Comments from Environmental Health

EH has **no objection** in principle, but the following specific issues would need addressing before first use as A3:

PROPOSED
FLOOR PLAN

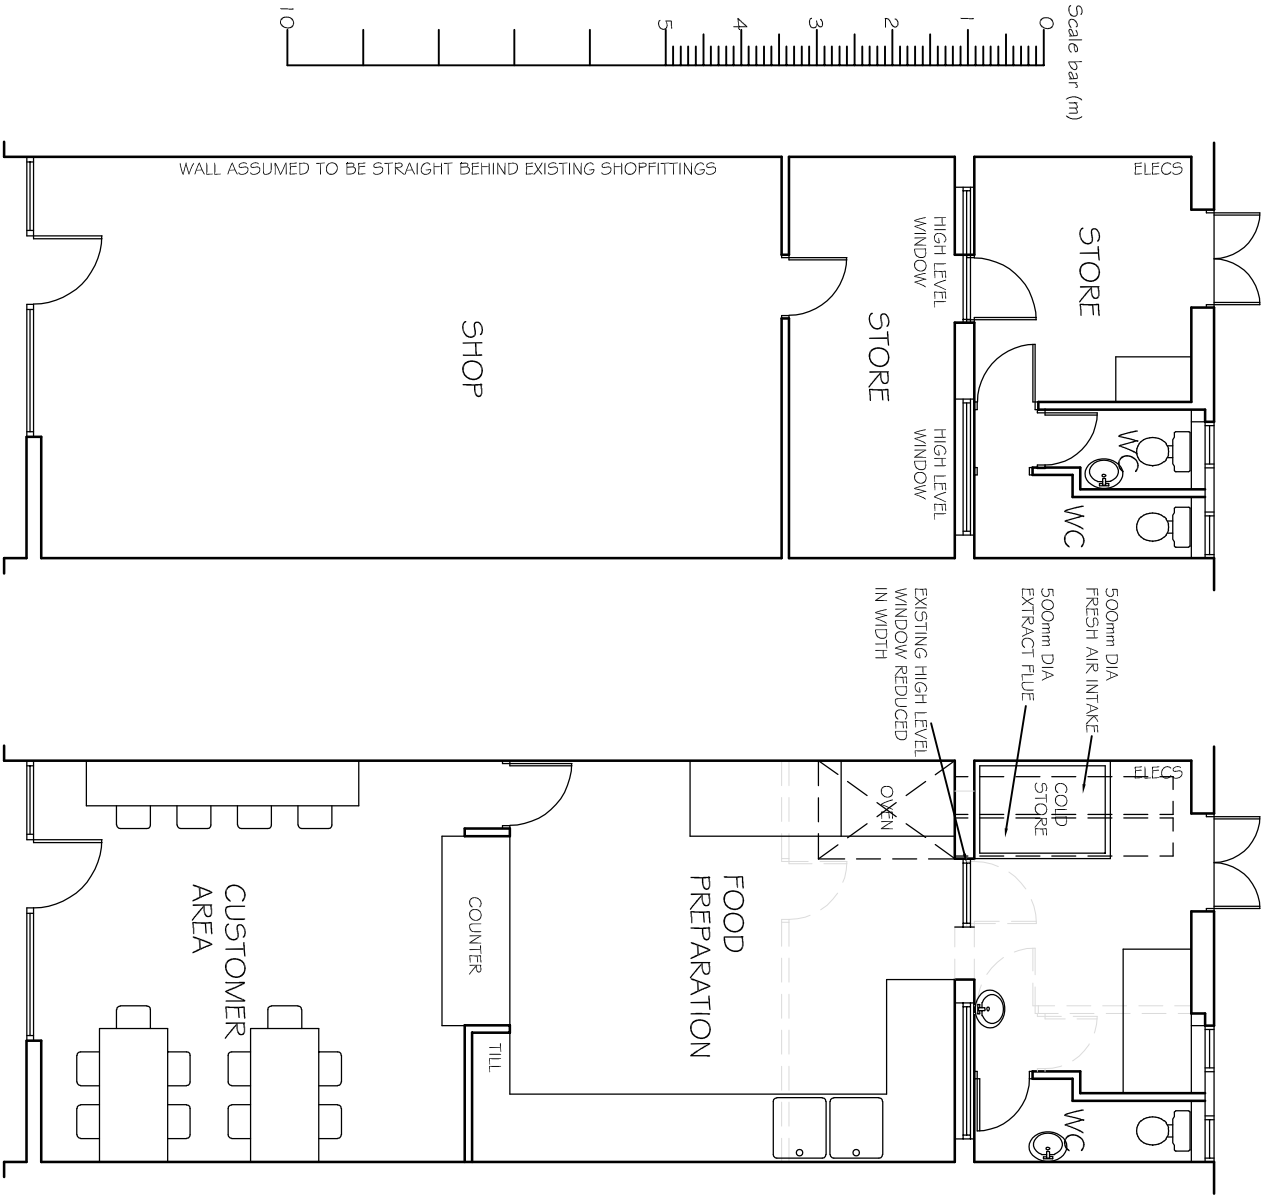
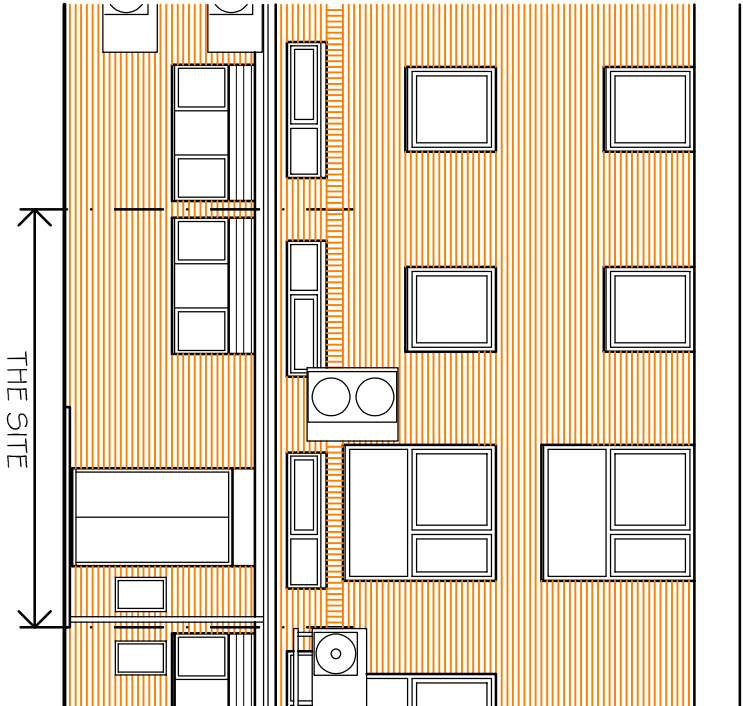
Firstly the layout plan shows a toilet opening onto the kitchen/food handling area without an intervening lobby, which does not comply with food hygiene requirements. Secondly, there is customer seating shown but no sanitary provision for customers. Please see below under Informatives.

8. The proposed floor plan currently shows only one toilet in the premises. The numbers of toilets required will depend on the number of staff and seated customers proposed. Any customer toilets provided must not be accessed via the kitchen or any food handling areas. Please note the requirements for toilet provision in Arun District which can be found at <https://www.arun.gov.uk/download.cfm?doc=docm93jjjm4n11788.pdf&ver=11779>
9. The granting of this planning permission does not in any way indemnify against statutory nuisance action being taken should substantiated complaints within the remit of the Environmental Protection Act 1990 be received. For further information please contact the Environmental Health Department on 01903 737500.
